**Epping to Thornleigh Third Track Proposal.** Application number SSI 5132.

I/we object to the Epping to Thornleigh Third Track Proposal and consider that the EIS is inadequate and does not address the full impact of this proposal. It will cause untold damage to the health of residents and to the fabric of the Beecroft Cheltenham Heritage Conservation Area. Do not approve this project, reconsider the alternatives and protect the community.

Figure S.6 Cross-section and elevation - New Cheltenham Station concourse building (see also S.5 for artist's impression)

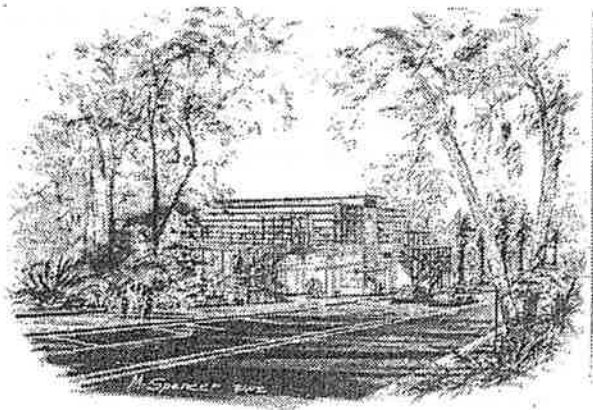
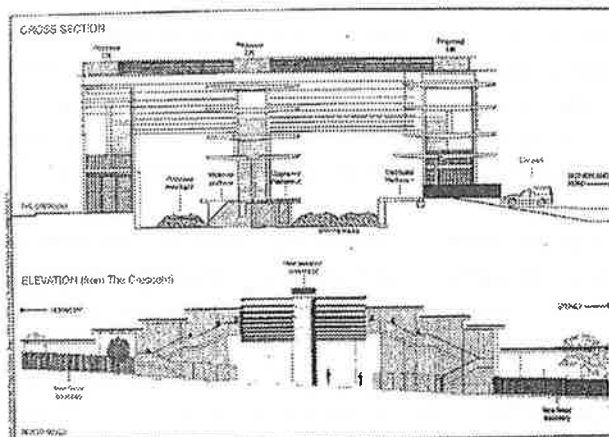
- The proposed redevelopment of Cheltenham Station shows no regard for the HCA. The visual impact of the proposed 13m high glass and steel concourse is totally unacceptable in this HCA.
